EPC STORMWATER REVIEW COMMENTS
 IN ORANGE BOXES WITH BLACK TEXT

WOODMOOR WSD NO. 1
 WELL NO. 22
 EL PASO COUNTY, COLORADO
 SITE DEVELOPMENT PLAN

SHEET NO.
FIG-1

SHEET NO.  
**FIG-1**

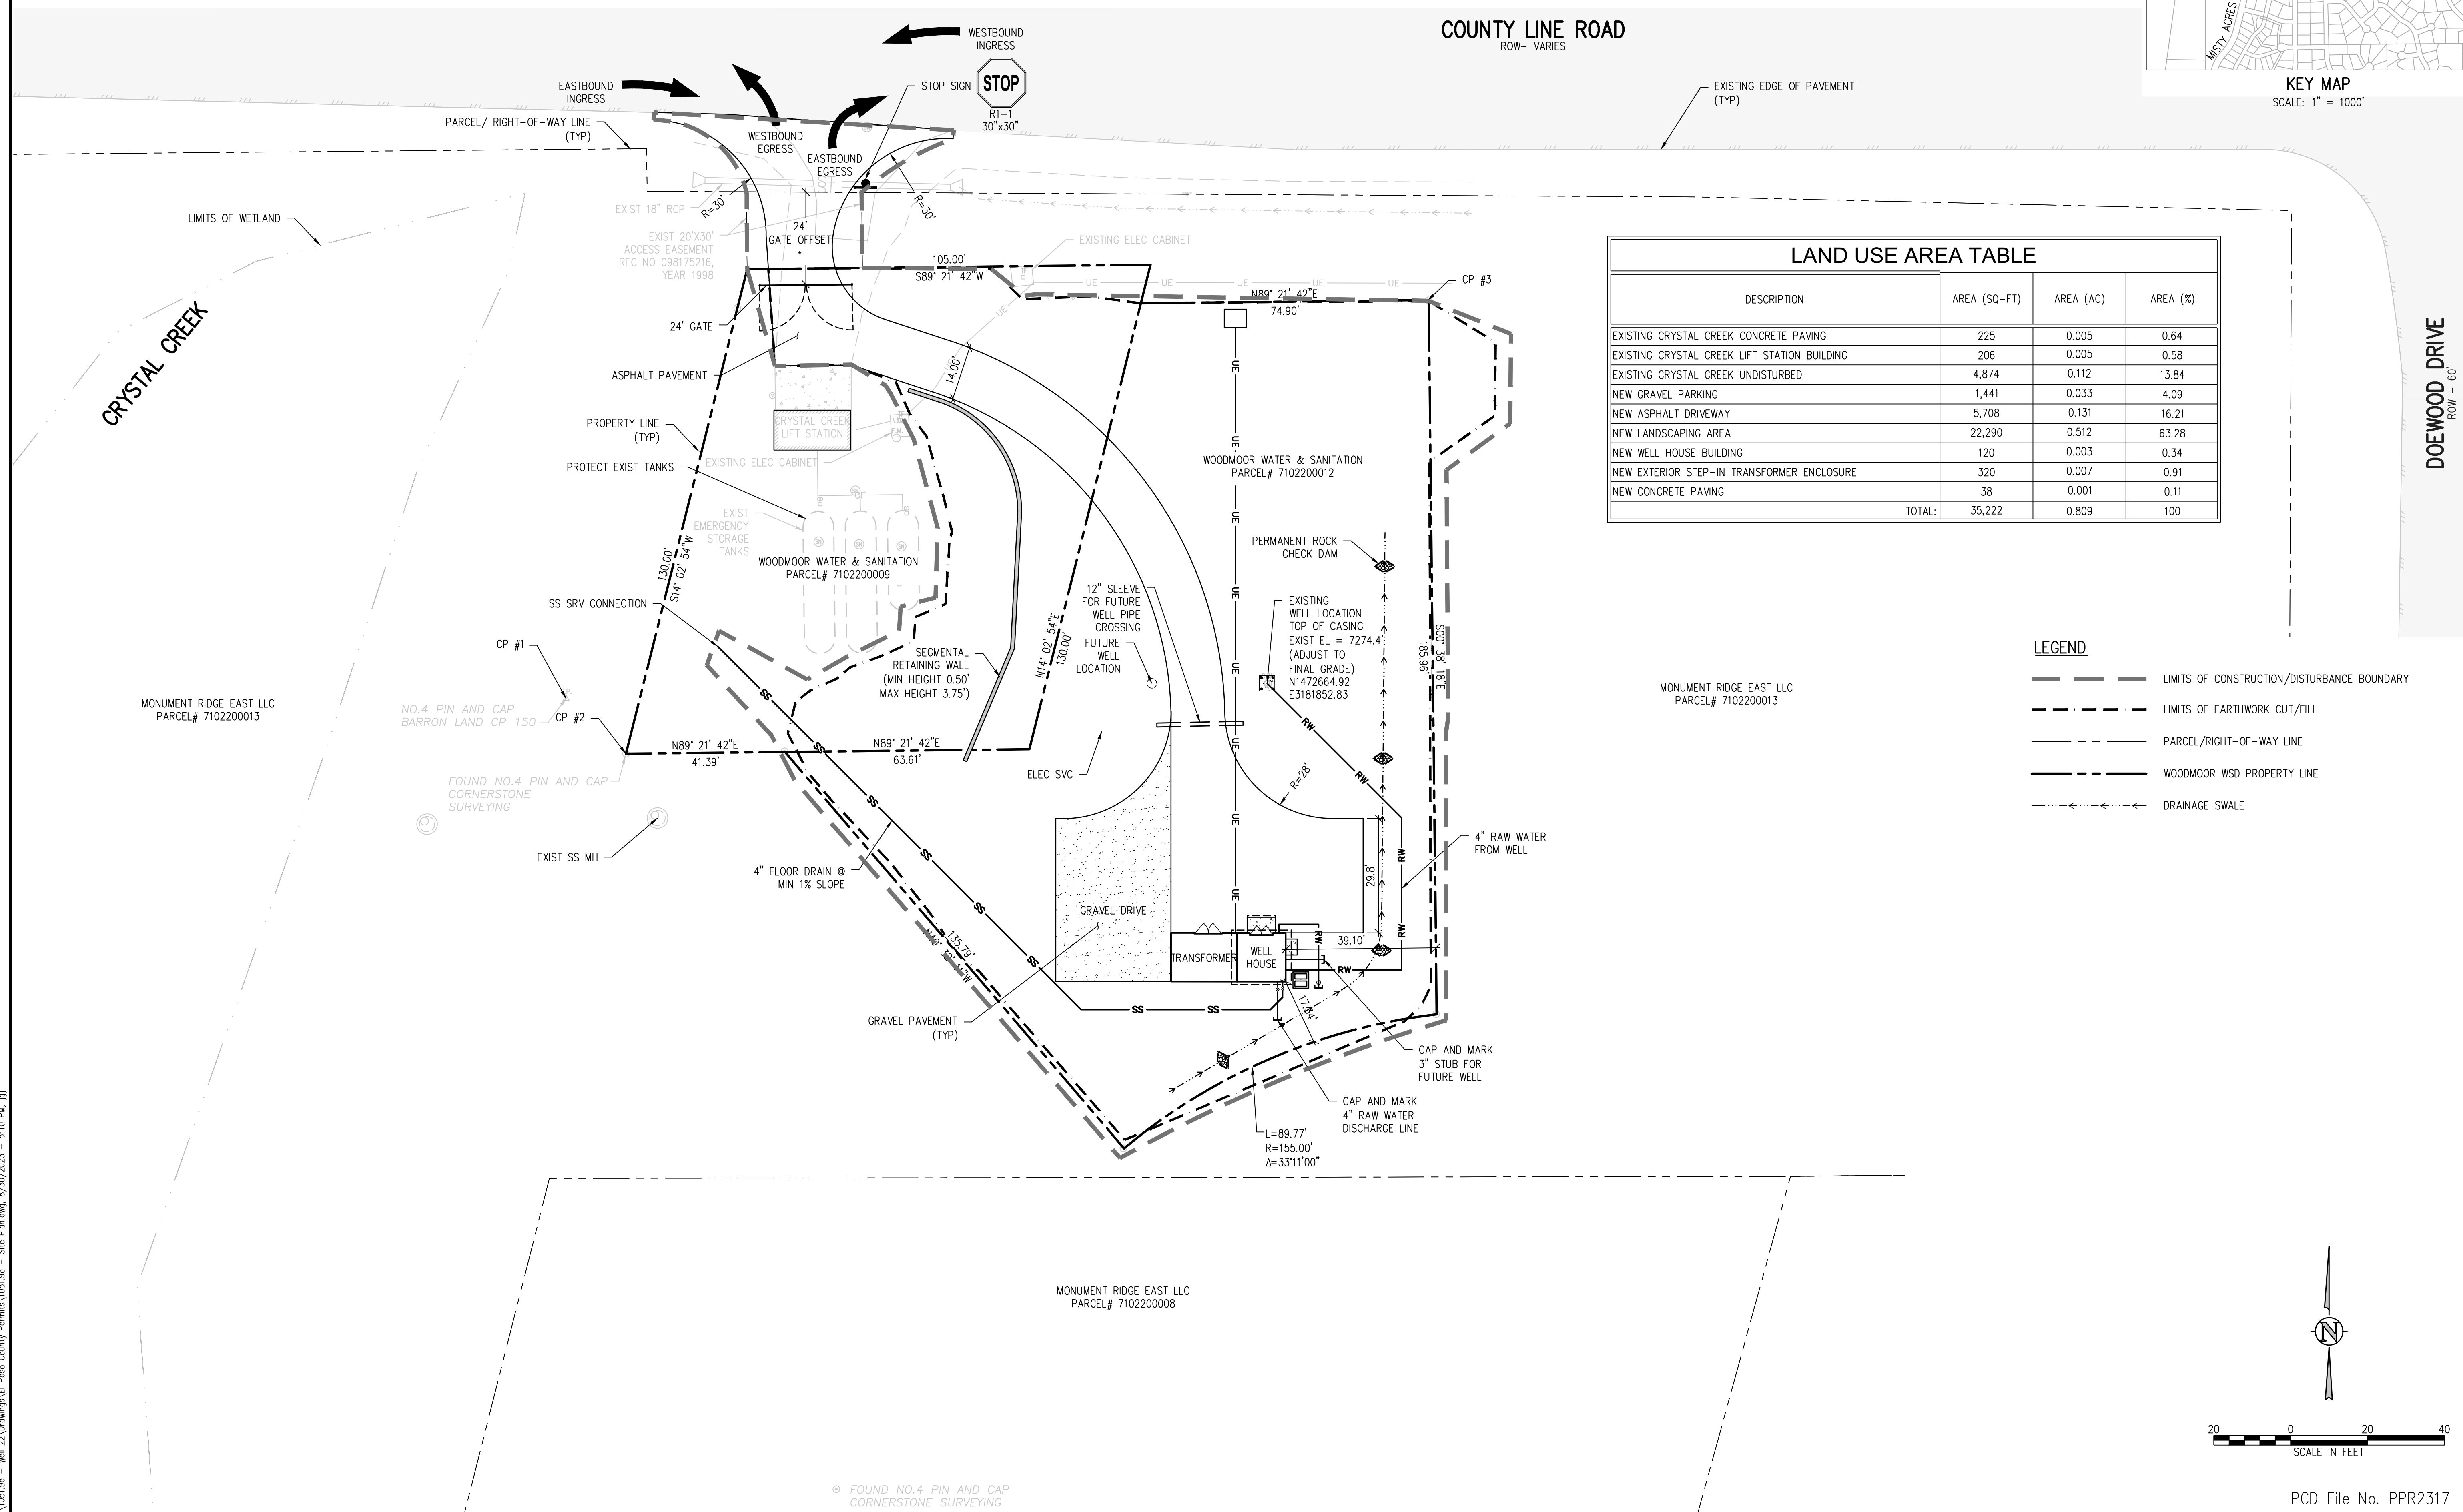
Please depict:
 -Traffic ingress/egress on property
 -Location and height of any fencing, walls, or berms
 -If there is signage:
 . location and dimensions
 - Lot area coverage percentage
 - Open space, landscaping, and impermeable surface percentage
 - Total gross building square footage

Add "PCD File No. PPR2317"
